Your ref:	87c Saltram Crescent - FULL	Please reply to:	Phoebe Graham
Our ref:	20/08350/FULL	Tel No:	07971 024216
		Fee Queries:	0207 641 6500;
		Email:	planningreception@westminster.gov.uk;
Mr George Kain Fast Plans 6 Winsham Grove London SW11 6ND www.fastplansuk.co.uk		Incomplete Applications Development Planning City of Westminster PO Box 732 Redhill, RH1 9FL	
			6 January 2021

Address: Second Floor Flat, 87 Saltram Crescent, London, W9 3JS,

Proposal: Erection of rear dormer and installation of Velux windows to front elevation and skylights to rear roof.

PROPOSED SECTION AA
SCALE 1:50

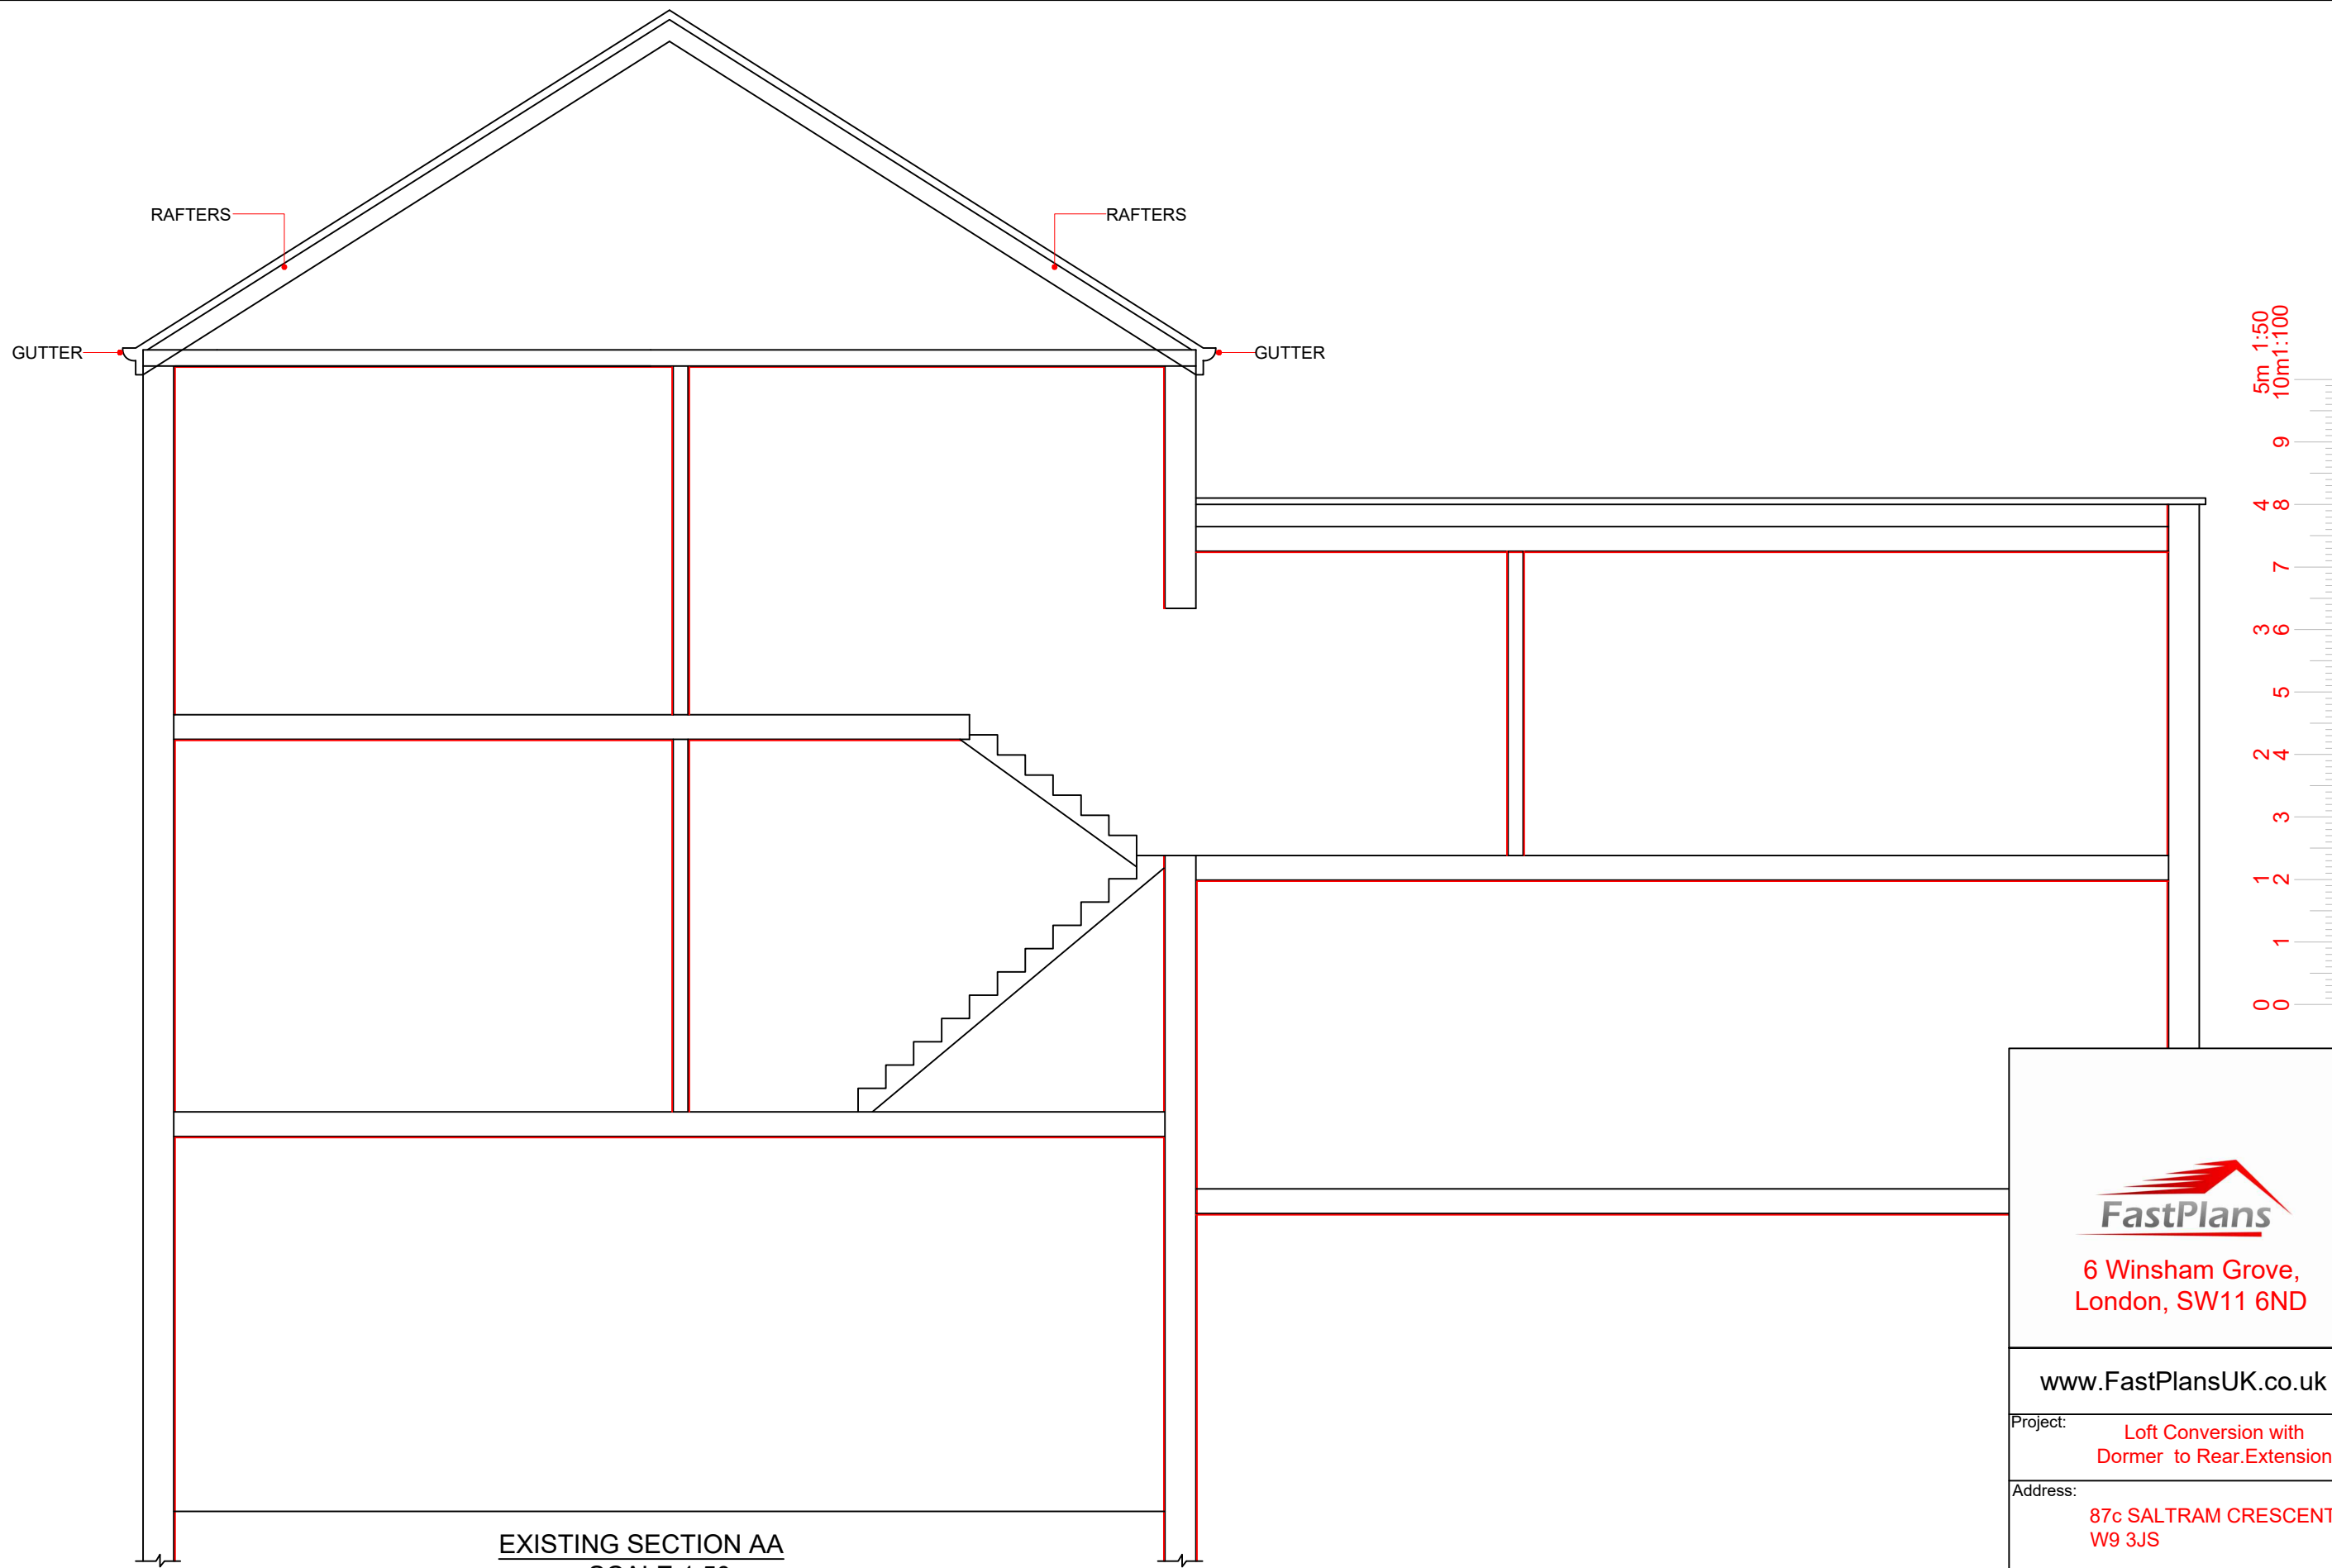
- existing section AA
